City of Albuquerque Stormwater Construction Site Inspection Report

ESC File No.	G11E069	Project Name:	Coors Pavilion at St Josephs		
NPDES Id. No.	NMR10052A	Location:	Coors Blvd and St Josephs Dr NW		
7/21/2023	Owner	Contractor			
Operator	Red Shamrock 4 LLC	Skarguard Construction LLC			
Contact name & title	Joshua Skarsguard	Jason Skarsguard			
e-mail	josh@skarsguardfirm.com	jason@skarsco.com			
Contact Phone #	505-262-2323	505-803-3757			
COA Inspector	Chancellor English	Start/End Time:	930am		
Construction Phase:	Grading/stockpile				
Type of Inspection:	Regular	Storm Event	Post Storm Event >0.25"	311/Complaint	Follow Up
Weather at time of inspection?	Clear		Temperature: ~	90	
Estimated date of last storm 0.25" or greater	5/22/2023

C-1

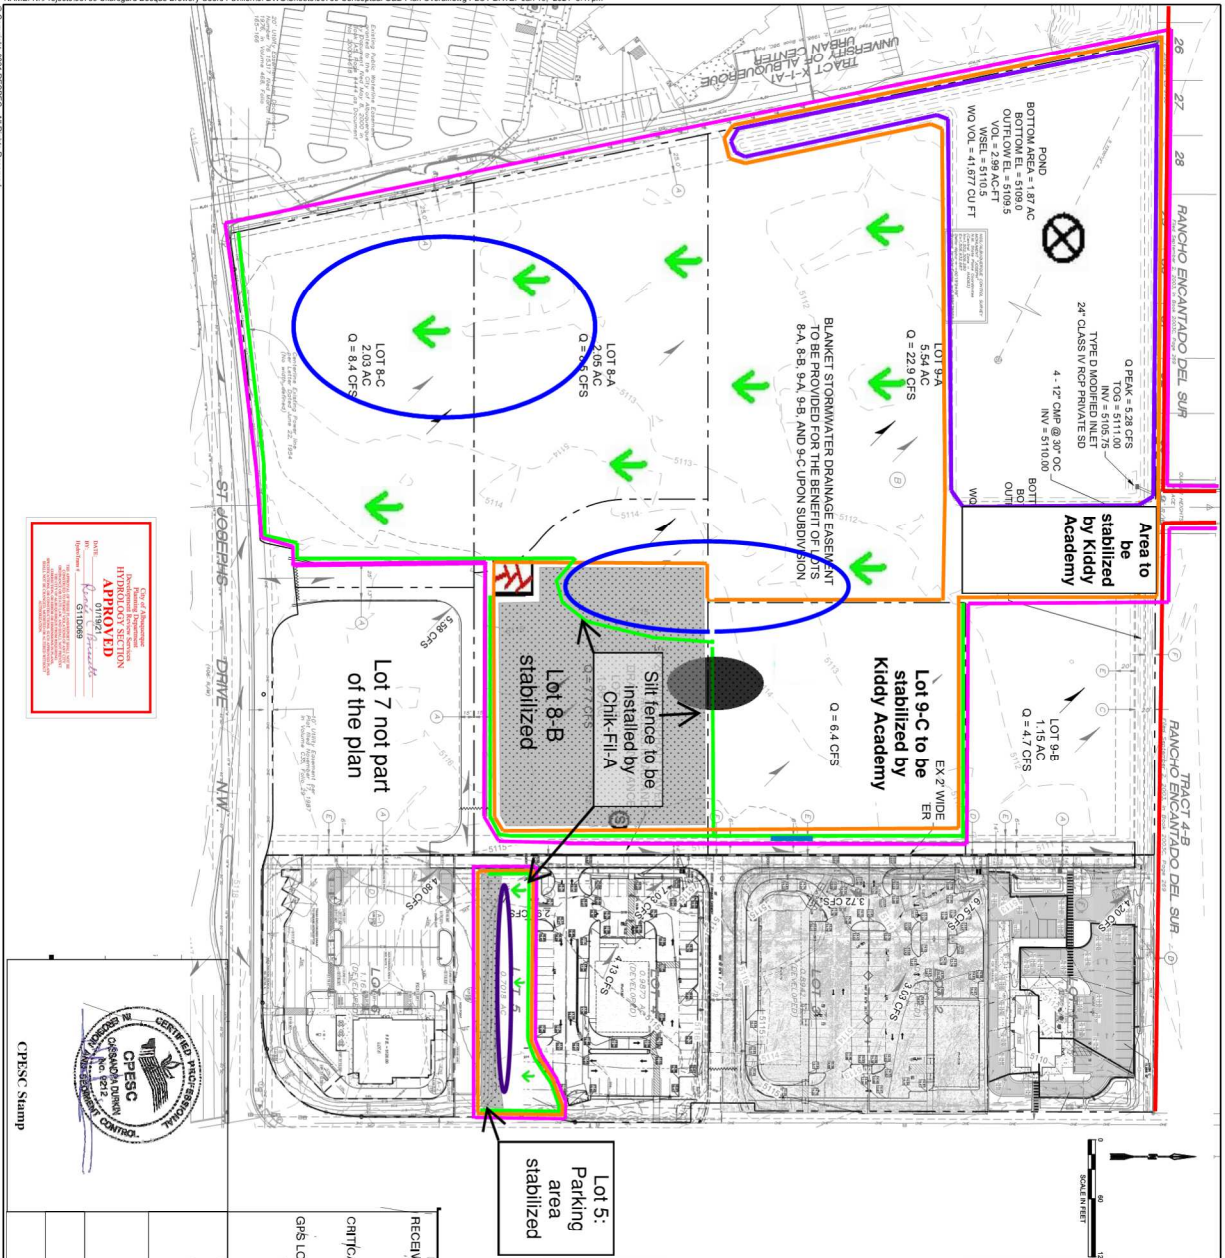
3	BMP - Several areas of the perimeter silt fence have collapsed or degraded and are in need of maintenance. Required mitigation: Ensure that perimeter controls continue to work effectively as per CGP Section 2.2.3.			
4	Stabilization - Stockpiles on Lot 5 and southwest corner are exposed and not stabilized or covered. Required mitigation: Manage stockpiles or land clearing debris piles composed, in whole or in part, of sediment and/or soil as per CGP Section 2.2.5. Section 2.2.5.c states that for piles that will be unused for 14 or more days, you must provide cover or appropriate temporary stabilization consistent with Section 2.2.14.
